OUT19/13875

McPhillamys Gold Mine Project (SSD 9505)

DPI has reviewed the project and has the following comments and recommendations.

Figure 30 Final Landform Surface Water Management Layout

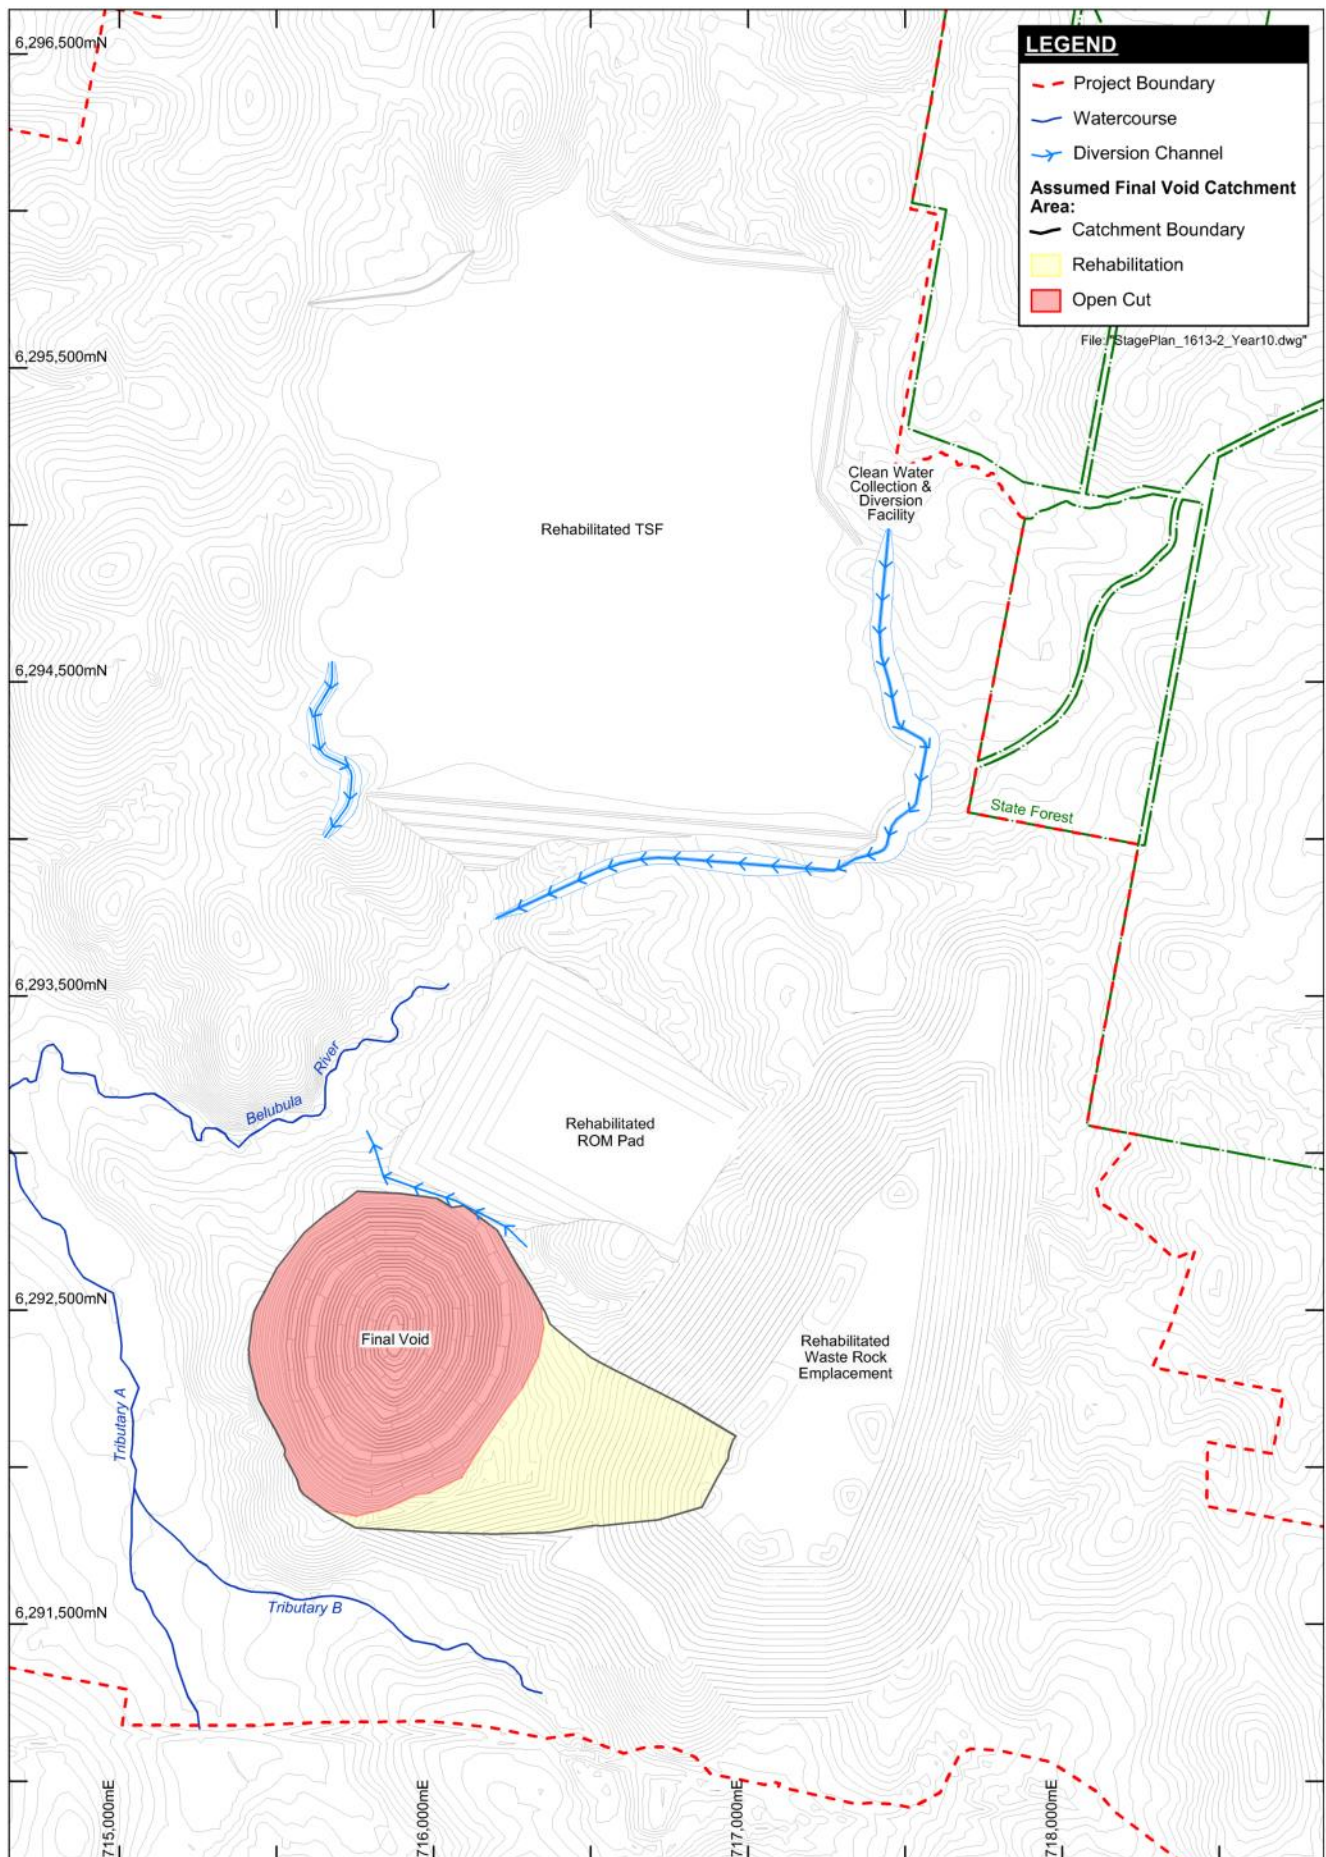
Final Landform - Permanent Clean Water Diversion Channels

There is minimal information regarding design objectives for the reinstatement of previously existing watercourses in the post mining landscape.

The post mining landscape should have waterways that have similar characteristics in terms of stream type, alignment (where possible), riparian zone width and longitudinal grade to the existing watercourses. Where existing watercourses are degraded, the reinstated watercourses in the post mining landscape should aim to improve on or at the very least maintain existing aquatic and riparian attributes.
